Planning Department
Allen Varela, Director

April 29, 2022
Kelly Fetter
E2RC
439 South Hill Rd.
Bernalillo NM, 87004

**Re: Preserve at Woodmont – 7910 Paseo Del Norte NW
Erosion and Sediment Control Plan
Engineer's Stamp Date (4/4/2022) (C09E015)**

# THE PRESERVE AT WOODMONT

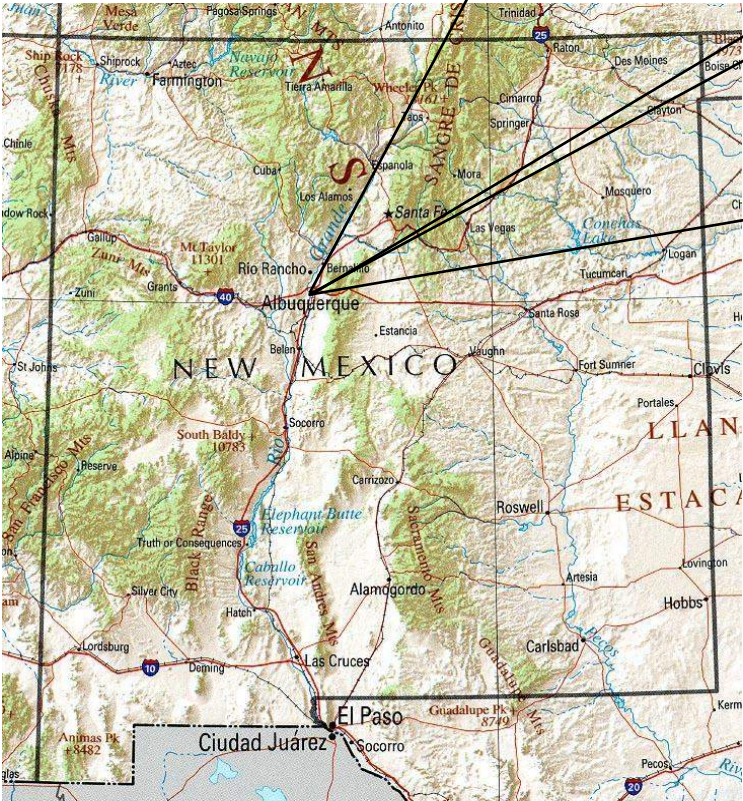
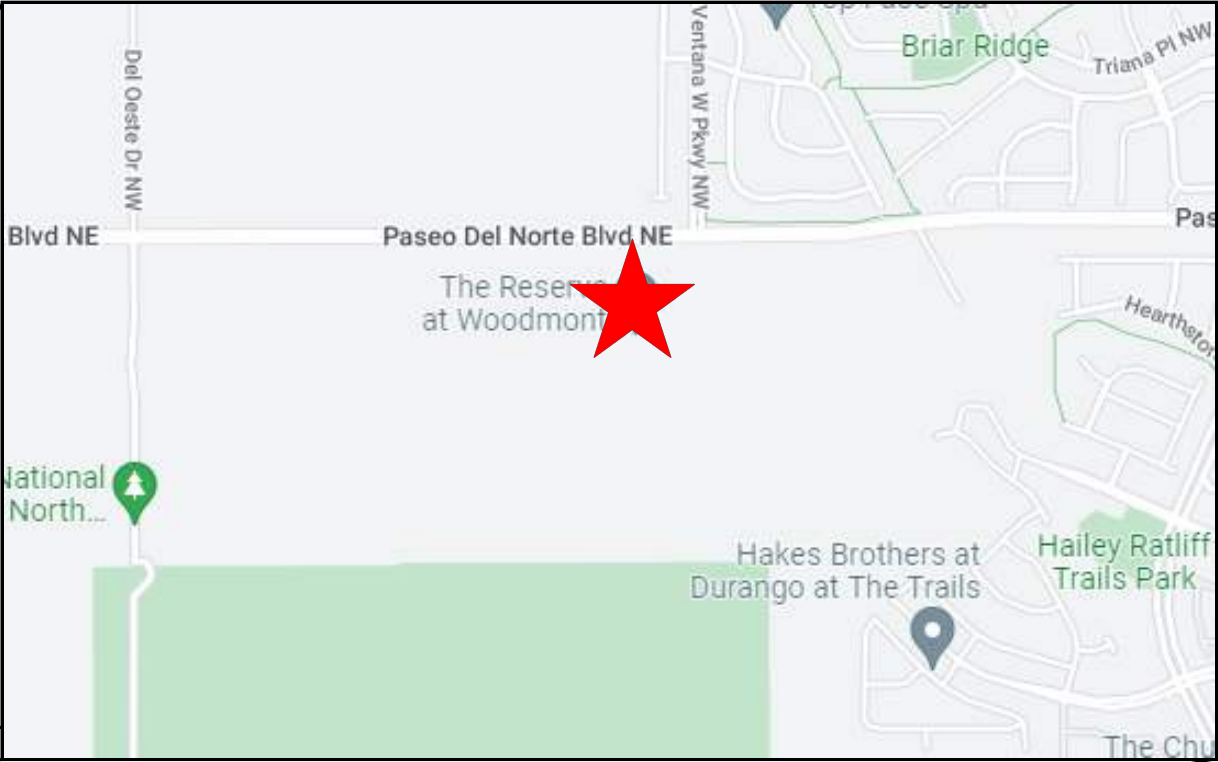
1. The ESC Plan can't be approved until the property owners' NOIs have been reviewed and approved by City Stormwater Quality per Albuquerque Code § 14-5-2-11(a). The NOI for PV Trails Apartments LLC is for an estimated area of 18.75 acres is satisfactory for the 17.35 acres controlled by PV Trails Apartments LLC including:
 - a. The 13.75 acre Tract 11 Catalonia
 - b. The 1.4 acre portion of Paseo del Norte in the WO
 - c. The 2.2 acre portion of Woodmont in the WO,However a 2 acre portion of Tract 4 of The Trails Unit 3 containing Pond C plus about 0.7 acres slopes on Tracts 3 & 4 are owned by PV Trail Albuquerque LLC (2.7 ac total). So either provide an NOI or an easement from PV Trail Albuquerque LLC.
2. The limits of Disturbance needs to be expanded to include the Portion of Paseo Del Norte and the slope on tracts 3 & 4 of The Trails Unit 3.

3. Include specifications for BMPs and interim and permanent stabilization per CGP 9.4.1.c.i. for the Work Order, Pond C, and offsite slope areas of disturbance associated with this site. Include a stabilization plan for the offsite WO areas that clearly shows limits of pavement, gravel, and vegetative stabilization.
4. Describe the nature and extent of construction activities in the offsite, Work Order portion of the site (CGP 7.2.2.), including a) nature of construction activities, c) size of disturbed area, d) description of construction support activities, e) size of maximum disturbed area, and f) Project Schedule. The current description is for the onsite 13.75 acre Tract 11 only.
5. Update the engineer's stamp date each time the plan is changed.
